From: Bob Neville
Sent: 01 March 2021 08:32
To: DC Support
Subject: FW: Planning notification for application reference: 20/03353/OUT

From: patrickprendergast@bucksplantcare.co.uk <patrickprendergast@bucksplantcare.co.uk>
Sent: 26 February 2021 11:42
To: Bob Neville <Bob.Neville@cherwell-dc.gov.uk>
Cc: Jonathan Emanuel <jonathan.emanuel@cherwell-dc.gov.uk>
Subject: RE: Planning notification for application reference: 20/03353/OUT

6.43 A tree survey was undertaken by RPS Arboricultural experts. The tree survey assessed the individual condition of all trees identified on the site, and were categorised using the method explained in BS5837:2012. This method categorises individual trees, groups and woodlands in systematic way. Each tree, group or woodland is identified on the tree plan submitted in support of this application.

JSL3972_700: TREE CONSTRAINTS PLAN

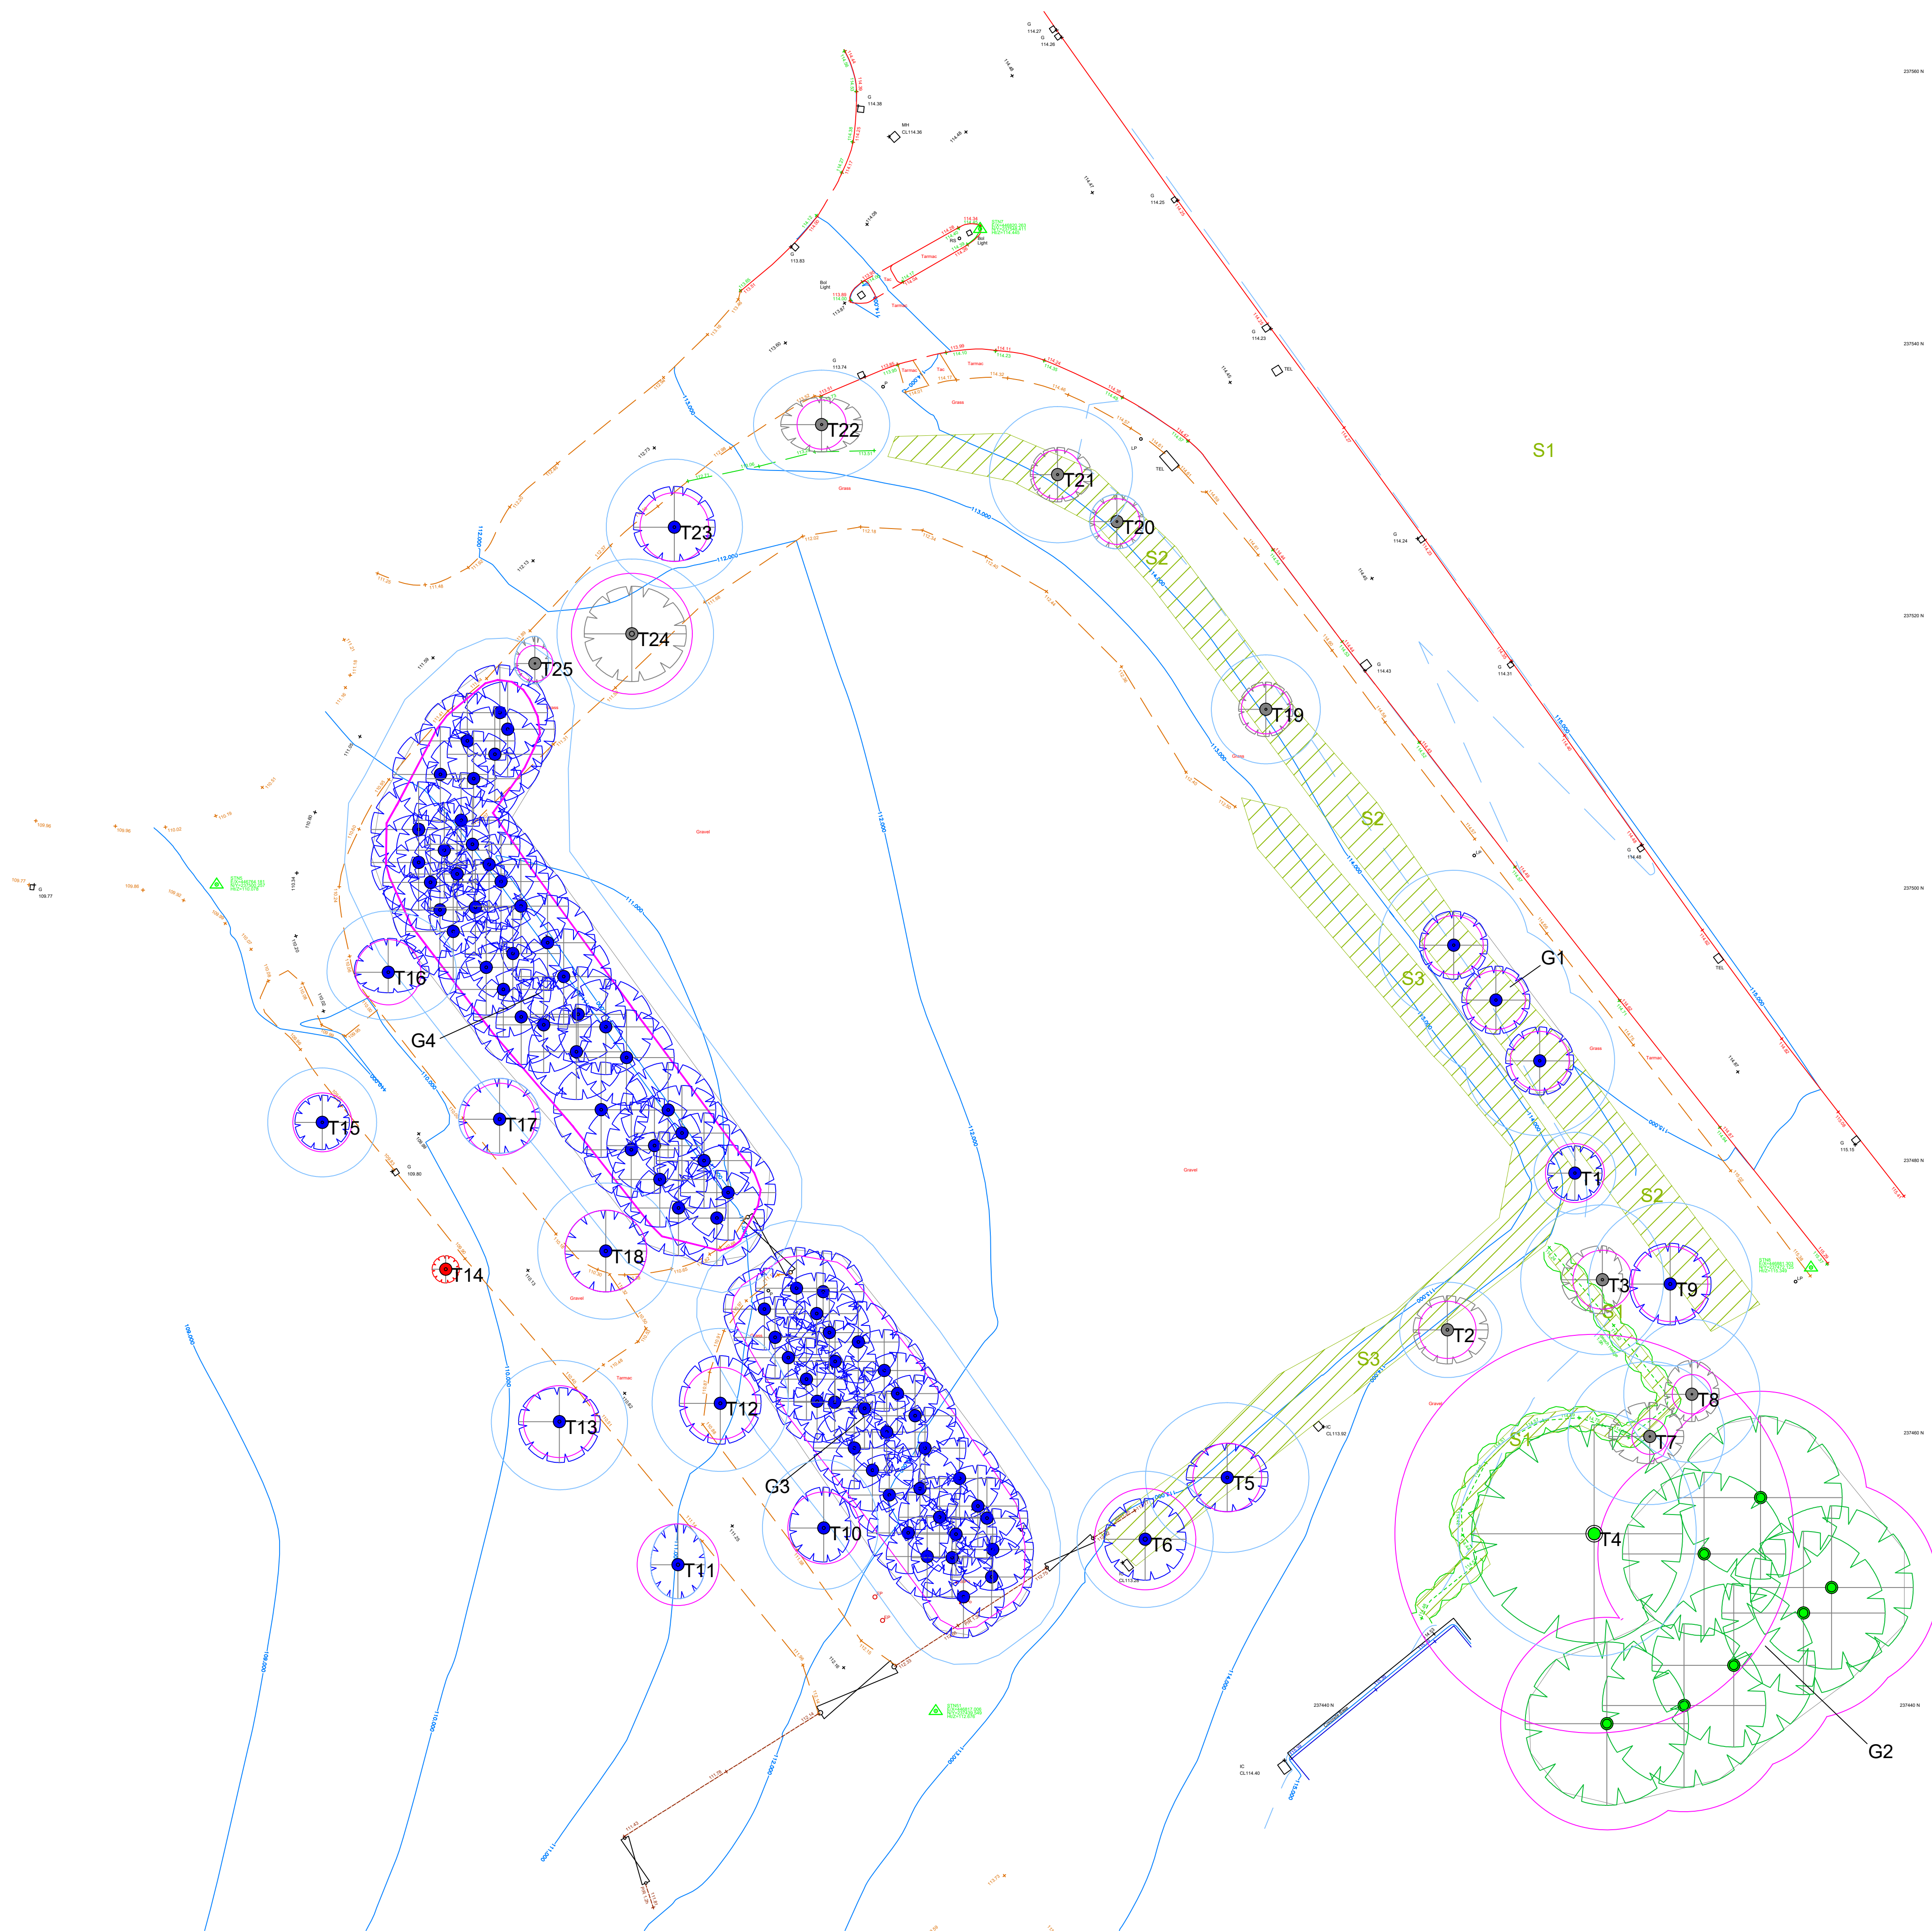
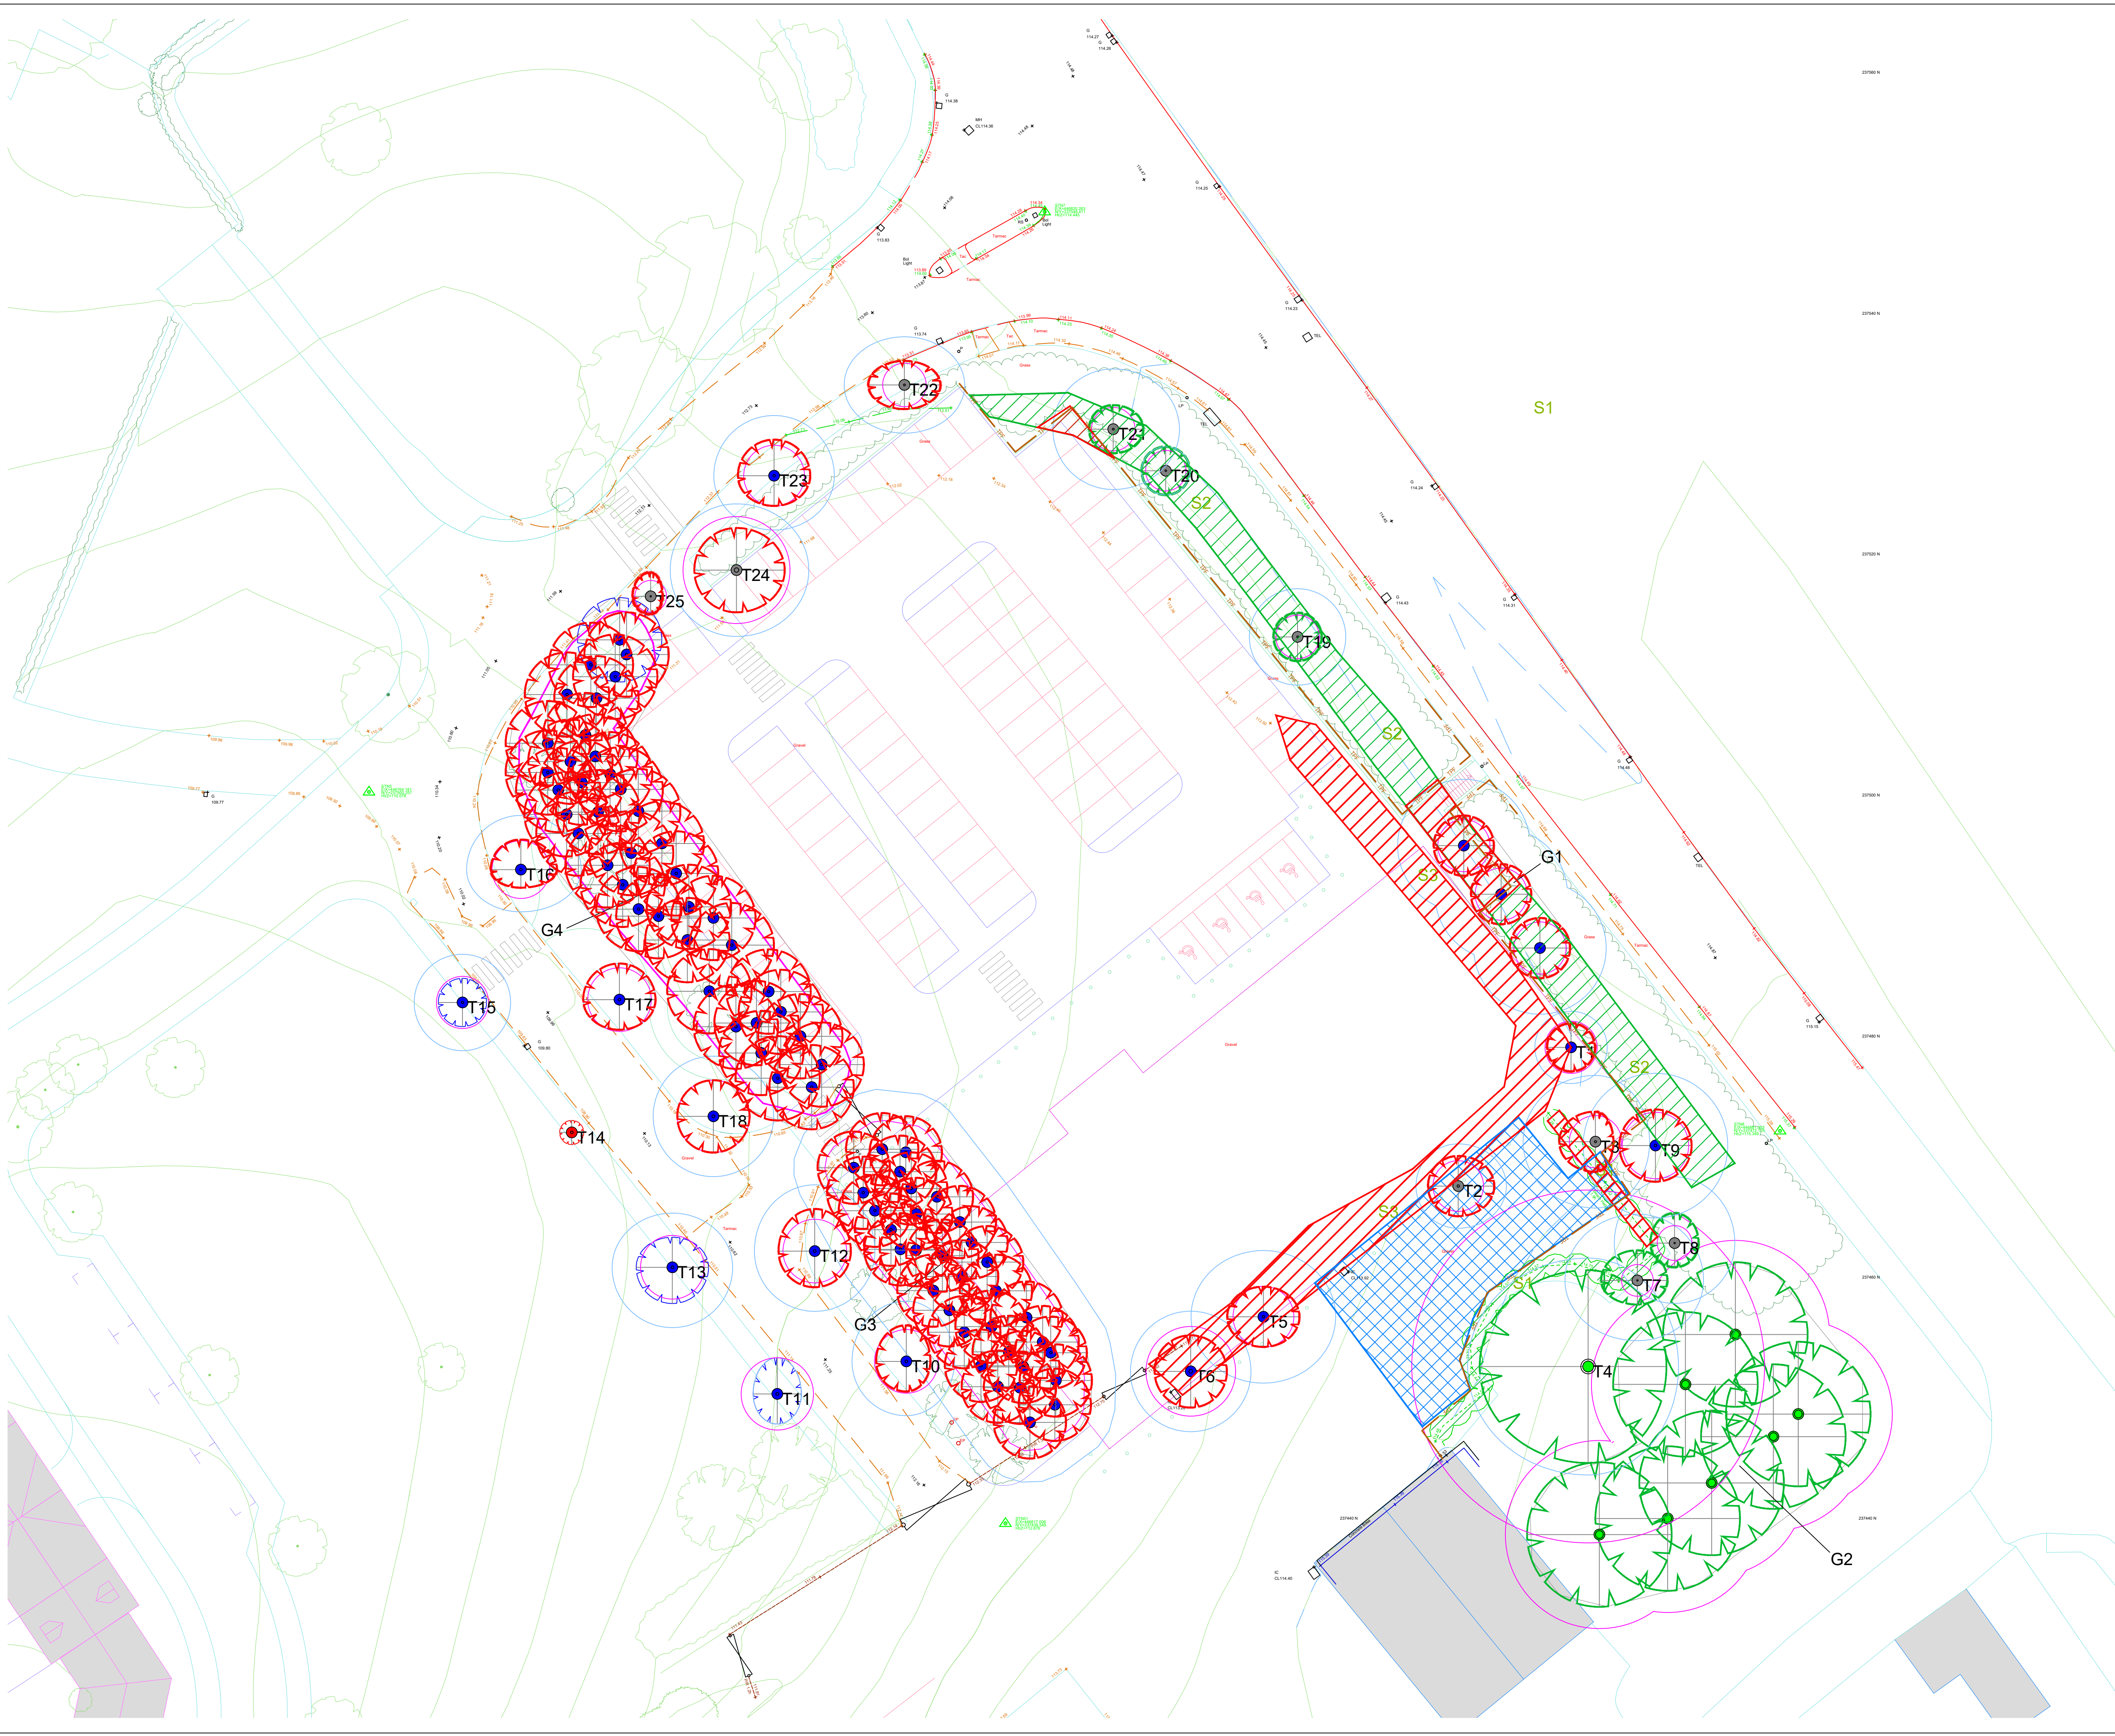
- 7.11 It will be necessary to remove the majority of trees recorded during the survey in order to implement the proposals for the site. This comprises ten Category B individual trees (T1, T5, T6, T9, T10, T12, T16-18 and T23) and five Category C individual trees (T2, T3, T22, T24 and T25). It will also be necessary to remove three Category B groups of trees consisting of G1, G3 and G4.
- 7.12 Some sections of existing scrub / hedging also to be removed are two small sections of S2 and the entirety of S3.
- 7.13 The losses to existing trees are clearly high, however there is scope to replant both within the new development and within the wider site. Due to the numbers involved, it is recommended that replanting in order to compensate the loss be undertaken.

So to recap in 6.44 of the D&A the protection and management of the trees on the site has been central to the design considerations of this scheme and the buildings has been positioned so that these trees are unaffected. But in 7.11 of the current tree report dated Feb 2021 it states it will be necessary to remove the majority of the trees.....

2. Furthermore the report does not discuss the impacts of the scheme on the trees and no impact assessment plan was submitted.
3. Also there was no discussion about mitigating the loss and no landscape plan submitted.
4. Just to enlighten us of the contents of policy ESD10

6. So with this layout all of this goes

It is clear that the trees were not considered sufficiently in the planning of this scheme. I suggest the layout is reconsidered in view of the above.
